CHAVEZ-GRIEVES / CONSULTING ENGINEERS, INC.

July 29, 1986

RE: DRAINAGE PLAN FOR SUNWEST BANK @ SIXTH & LOMAS (J-14/D62)

SHEET NO.
C-2

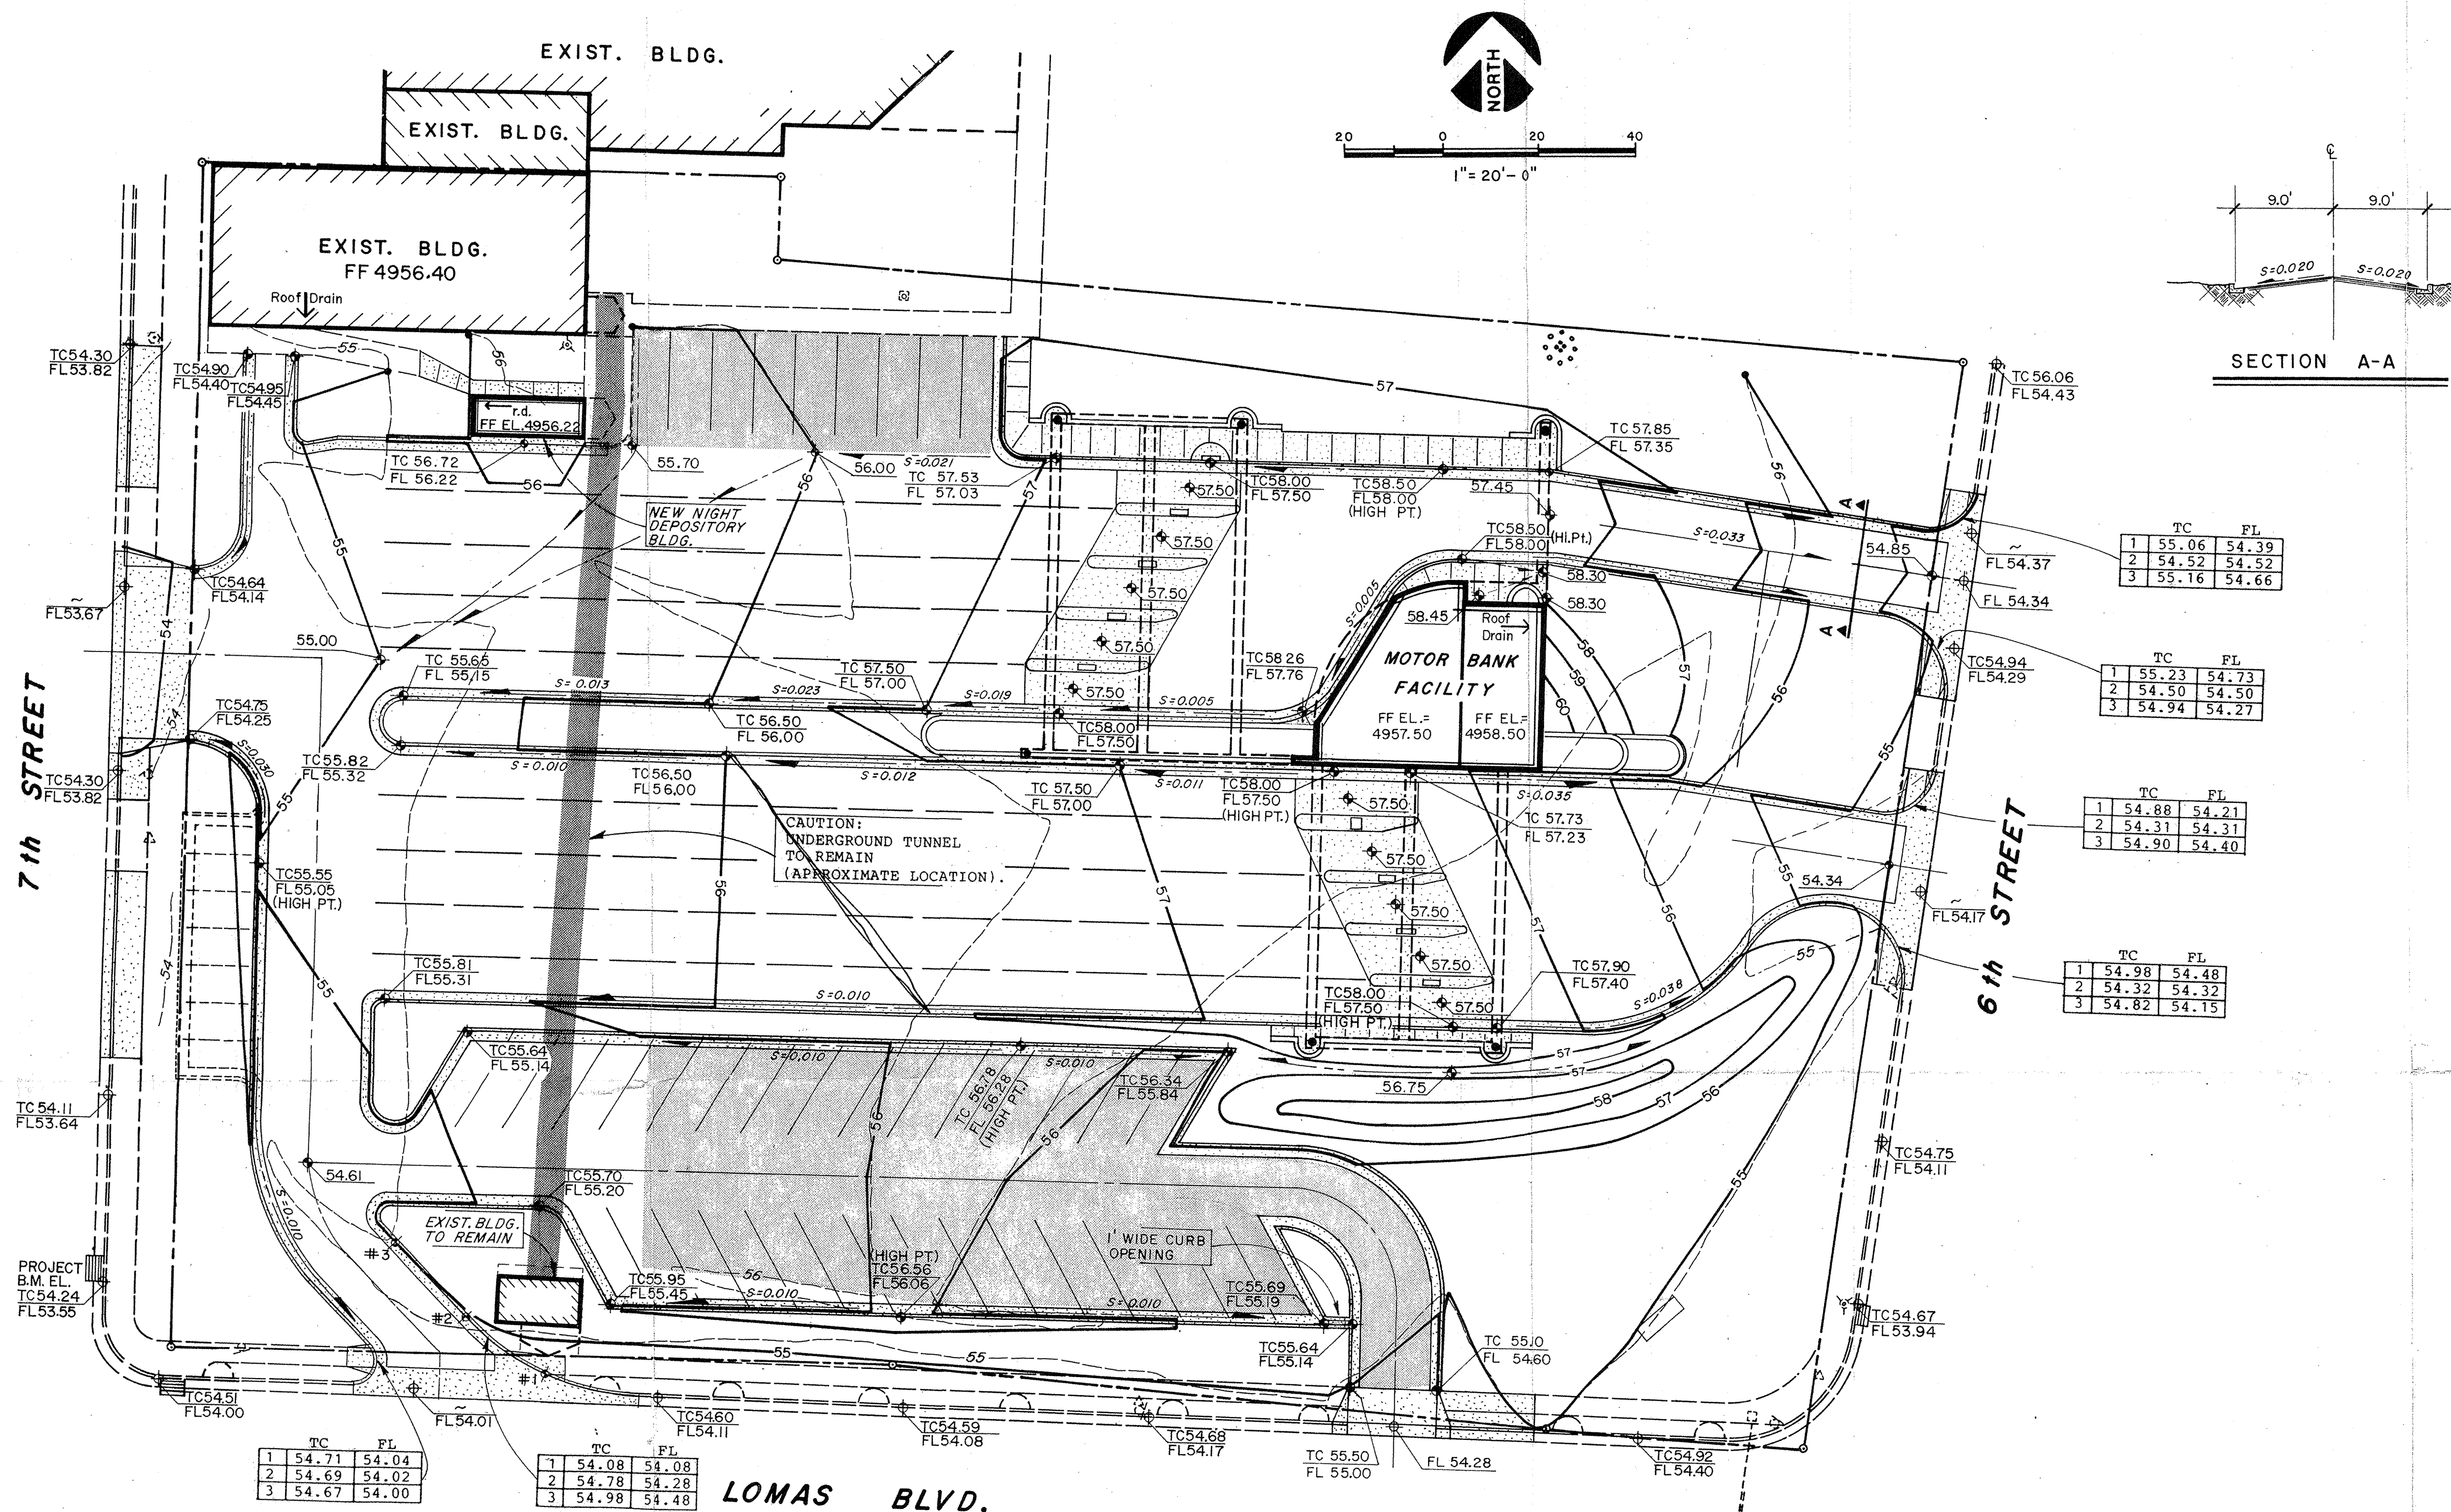
1. Note #6 on the plan states that the "Contractor is responsible for erosion control during the construction phase, including any provisions that need to be taken to divert any sediment from entering the city right-of-way". A specific type of erosion control was not stated because the site is already developed, the slopes are relatively mild and there may be no need for erosion control.
